From: Amanda Scholes on behalf of Planning.Responses
Sent: 31 May 2017 08:51
To: Planning Scanning
Subject: FW: Planning Consultation on: LU/121/17/RES

Comment from Greenspace

Registered: 19th April
2017
Site Address: Land North of Toddington Lane Parcel C1 & part
Parcels B2, B4 & C2 Littlehampton BN17 7PP
Grid Reference: 503051 103950
Description of Works: Approval of reserved matters following outline
consent LU/47/11/ for construction of 126 No.
dwellings together with internal road network, car
parking & landscaping.

Tree Planting Details LA108

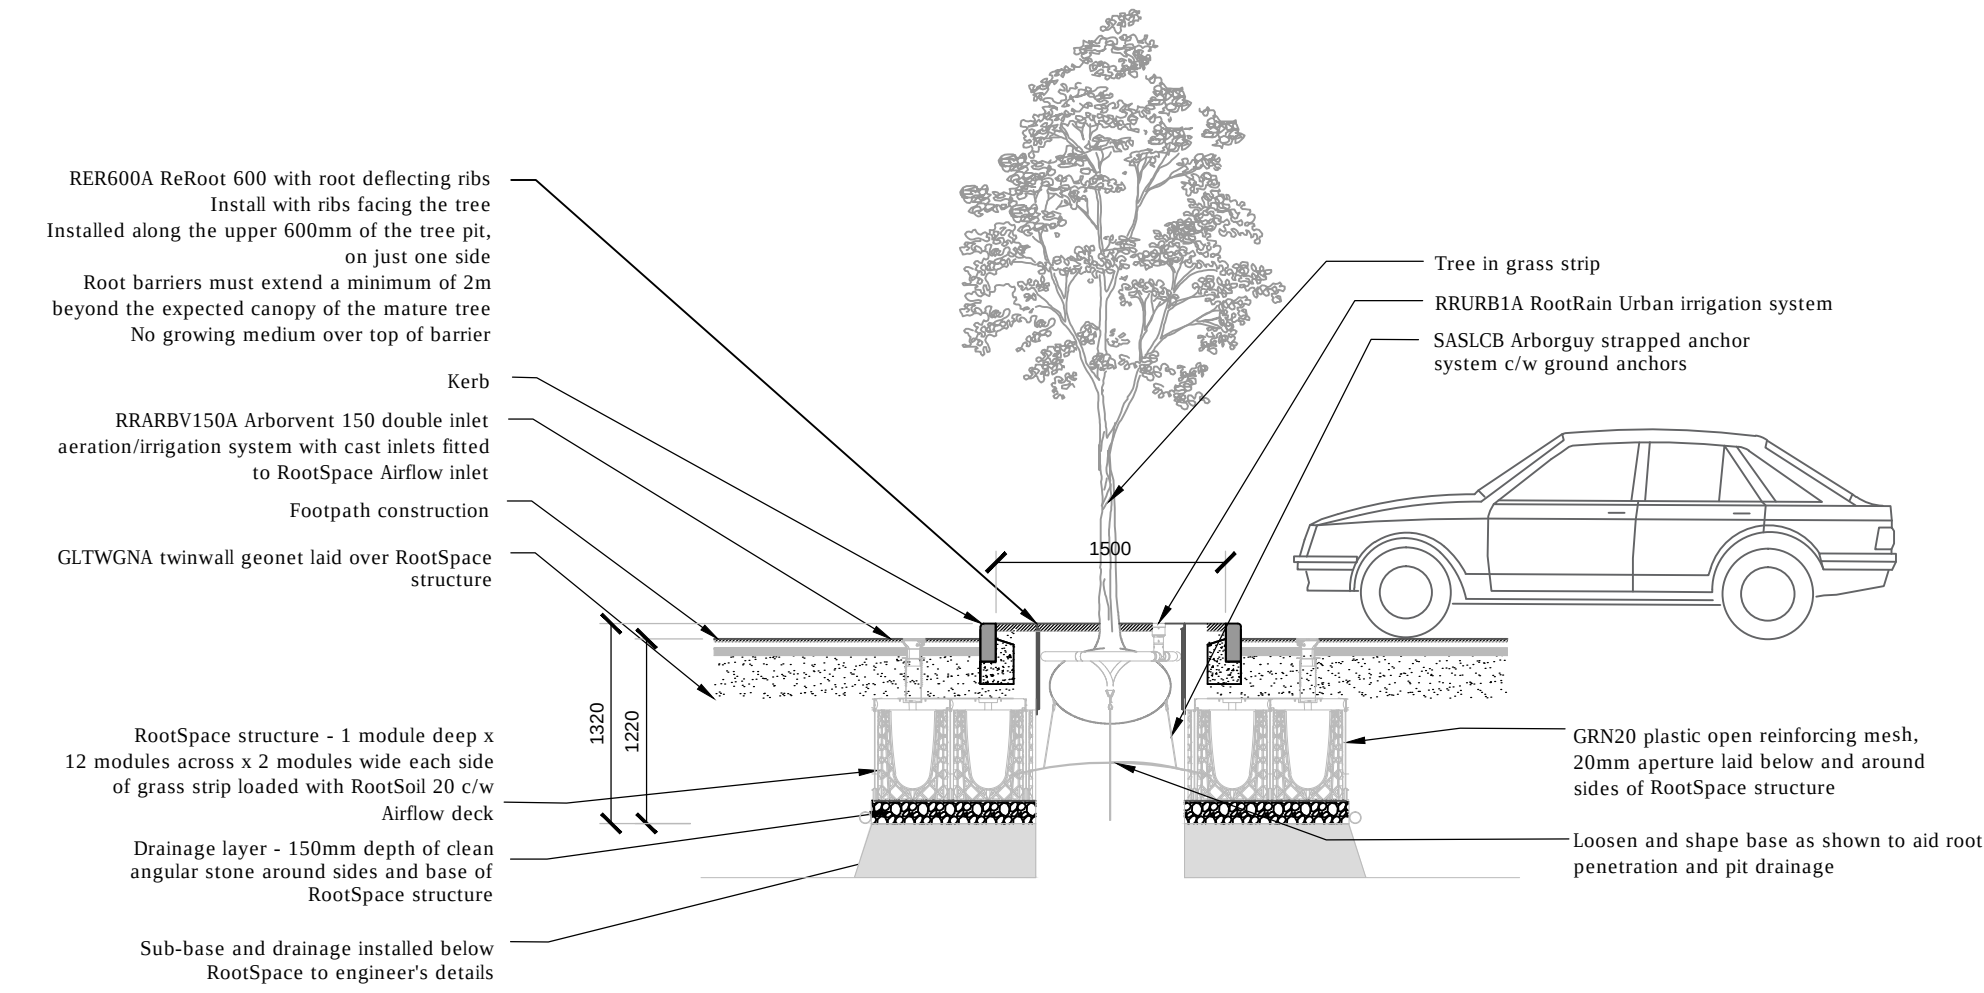
A planting pit formation cross section and specification would be requested for all trees and particularly for the proposed Betula to ensure that these have a viable rooting medium in which to support long term thriving growth and establishment.
